KITTITAS COUNTY

MEMORANDUM

TO: All Staff
FROM: Public Works Plan Review Team
DATE: February 4, 2025
SUBJECT: BL-25-00003 Graaff

GRAAFF PROPERTY

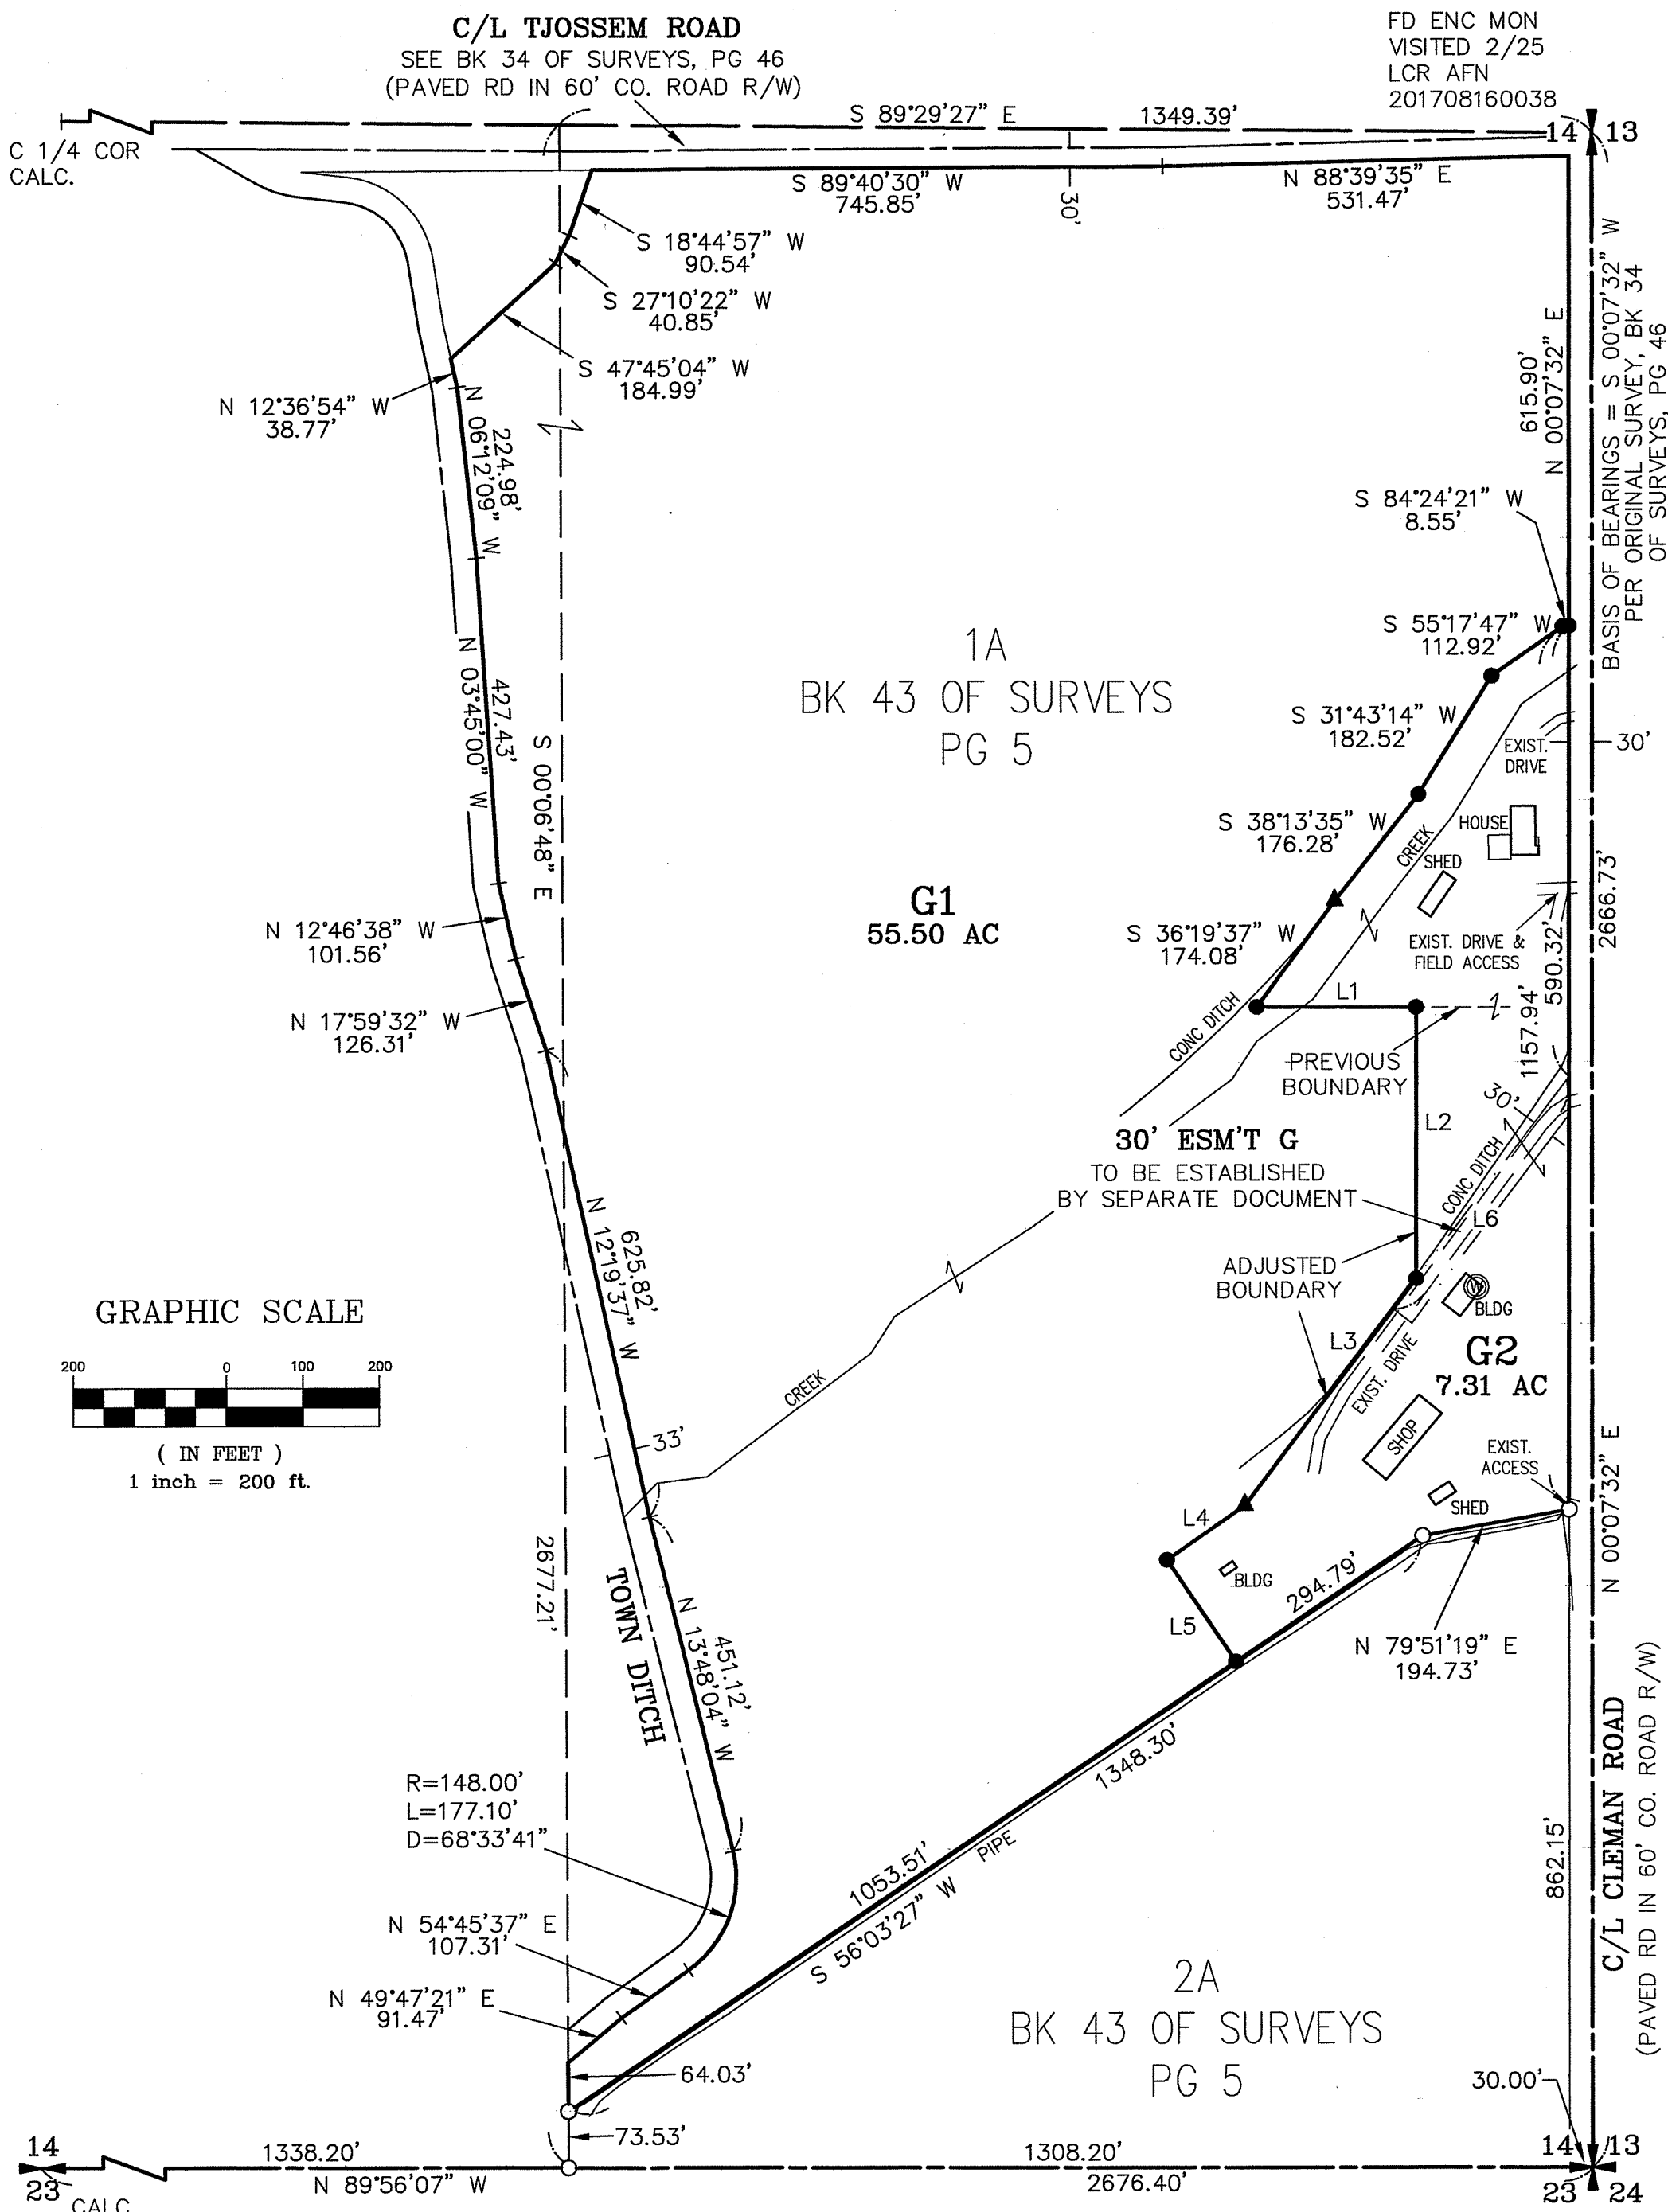
ACCESS	<ol style="list-style-type: none">1. An approved access permit shall be required from the Kittitas County Department of Public Works prior to creating any new driveway access or altering an existing access.2. KCC Title 12.04.07.050 states that residential lots have 1 access point. This newly created parcel will have 4 accesses, no additional accesses will be granted.3. Maintenance of driveway approaches shall be the responsibility of the owner whose property they serve. The County will not maintain accesses.4. Any further subdivision or lots to be served by proposed access may result in further access requirements. See Kittitas County Road Standards. <p>In addition to the above-mentioned conditions, all applicable Kittitas County Road Standards apply to this proposal. Access is not guaranteed to any existing or created parcel on this application.</p> <p>OFF NOTE: Ensure the newly created parcel retains all 3 addresses assigned to parcels 370233 and 10184. Addresses 1171, 1191(Guest House?) 1421 Cleman Road.</p>

FLOOD	<p>A portion of the proposed parcels are within the 100-year floodplain boundary. If possible, any future development should remain outside of the floodplain in order to reduce risk and avoid mandatory flood insurance purchase requirements. All activities within the floodplain must be permitted through the floodplain development permit process and follow the regulations within KCC 14.08.</p> <p>While not required by KCC 14.08.220, it is highly encouraged that the floodplain boundaries are outlined on the face of the recorded survey. (SC)</p>
WATER MITIGATION/ METERING	No comments. (SC)
AIRPORT	No comments. (JS)
